March 28, 2016

Re: Status of Improvement Permit Application # 16-5-38232 – Property at: Lt 1 NC 55 West

SITE PLAN APPROVAL

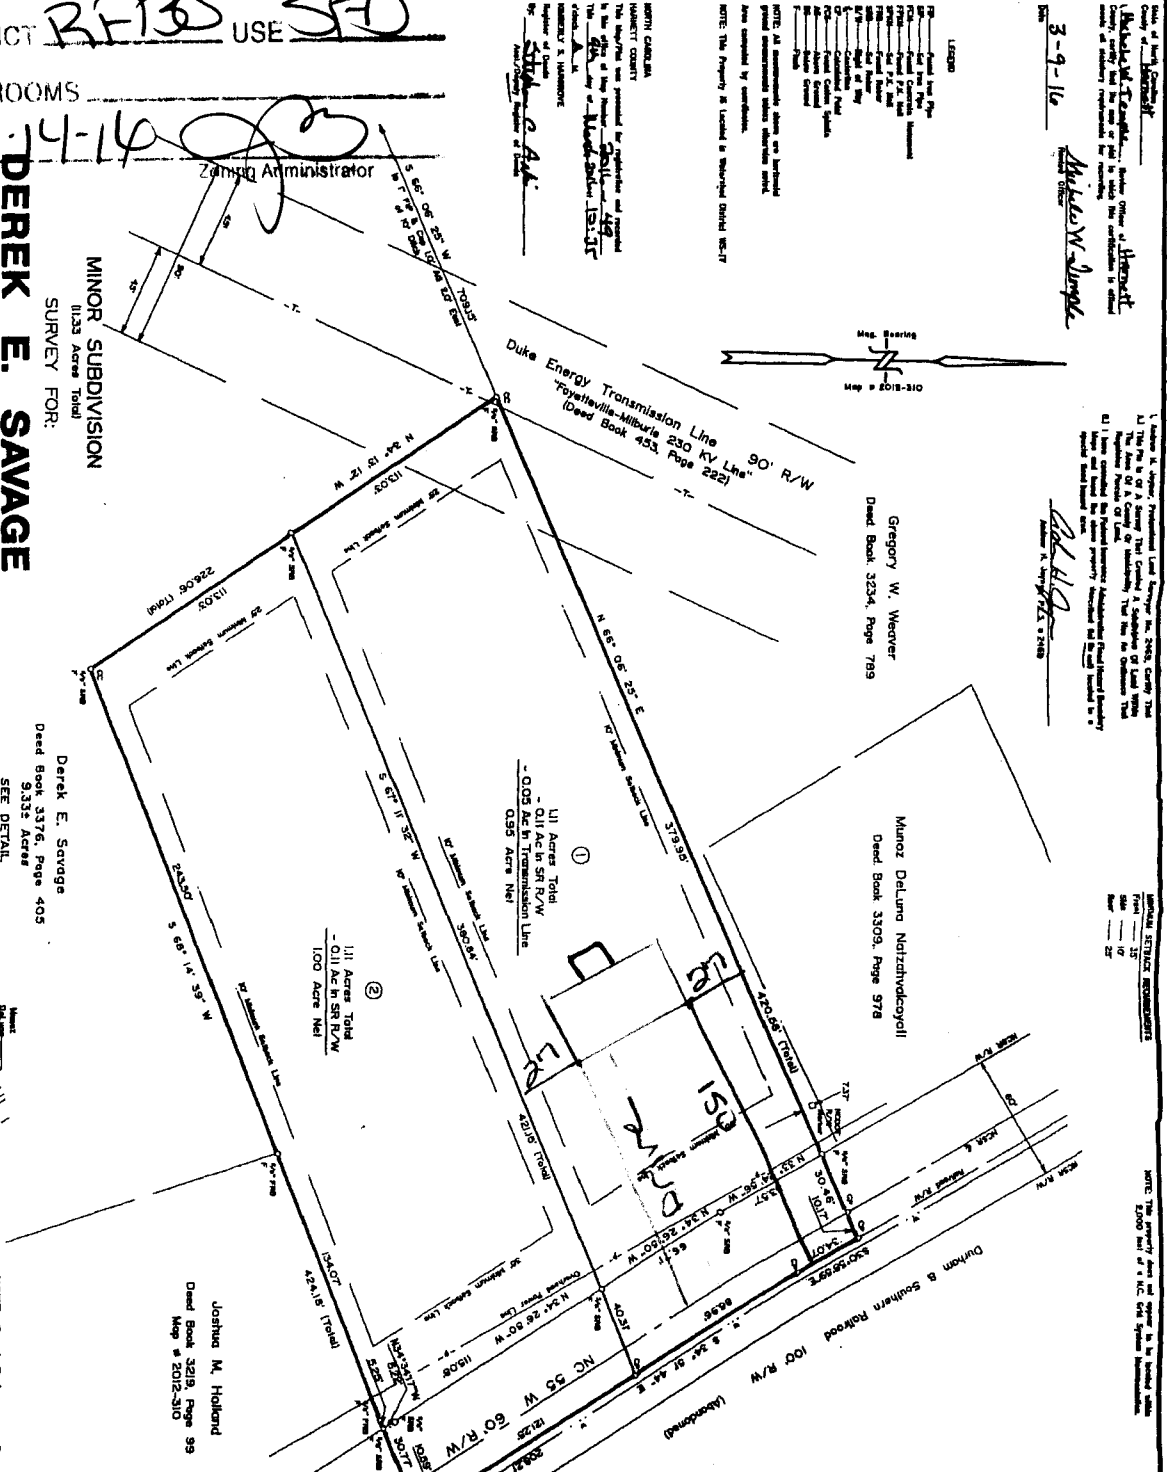
- 1. Use pink flags to mark property lines and irons that are set by surveyor need to be visible *(\$25.00 fee incurred)*
- 2. Use orange flags to mark house corners *(\$25.00 fee incurred)*
- 3. Directions not clear to property *(\$25.00 fee incurred)*
- 4. Property needs only brush or vegetation removed
- 5. **Driveway not shown on site plan. Show on site plan and mark.**
- 6. Backhoe pits required
- 7. **Other – Need setbacks, soil report, and clarify which lot is to be evaluated. Lot 2 was flagged in field but the site plan shows lot 1. Revise application.**
